From: Holly Duncan
Sent: Wednesday, August 29, 2012 1:49 PM
To: Jeff Watson
Subject: RE: BL-12-00022 Brenden

From: Jeff Watson
Sent: Tuesday, August 07, 2012 3:40 PM
To: Christina Wollman; Brenda Larsen; Jan Ollivier; Holly Duncan; Joe Gilbert
Subject: BL-12-00022 Brenden

[BL-12-00022 Brenden](#)

Map B.

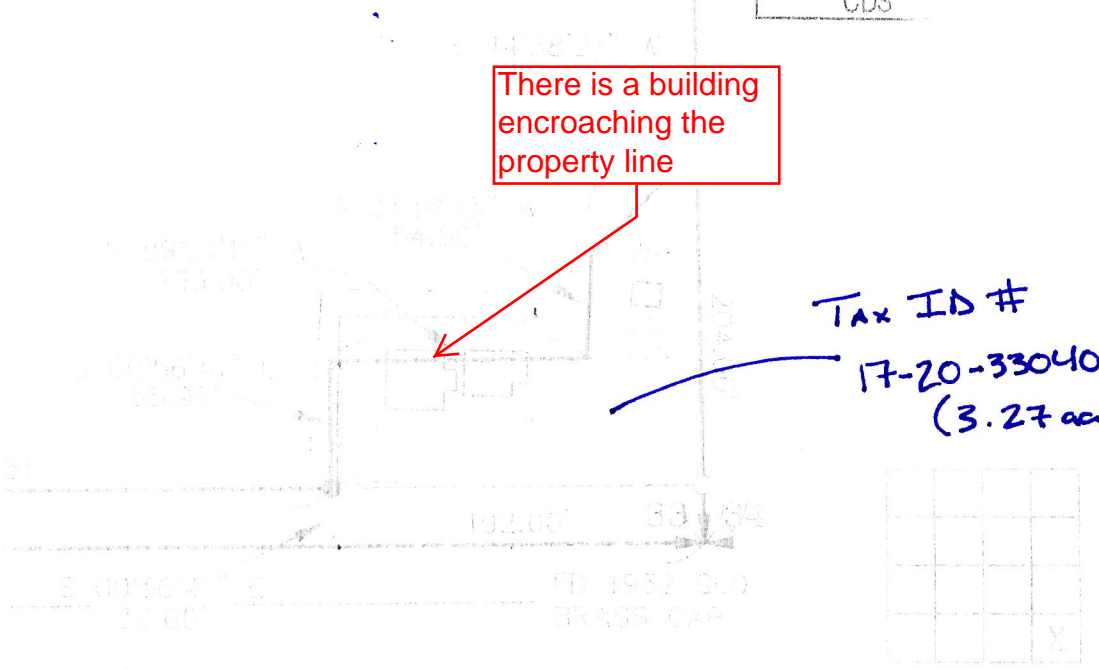
I can't see where the well is but as long as the new property line isn't within 50 feet of the well it should be OK.

Yes the originals are faint as well... I have rescanned as best I could and added some notes (attached). Essentially it is a structure encroachment issue and they are moving noted line what looks to be about 20 ft north.

I am having trouble commenting on this one because the current and proposed diagrams are not easy to see. I can't see any of the lines.
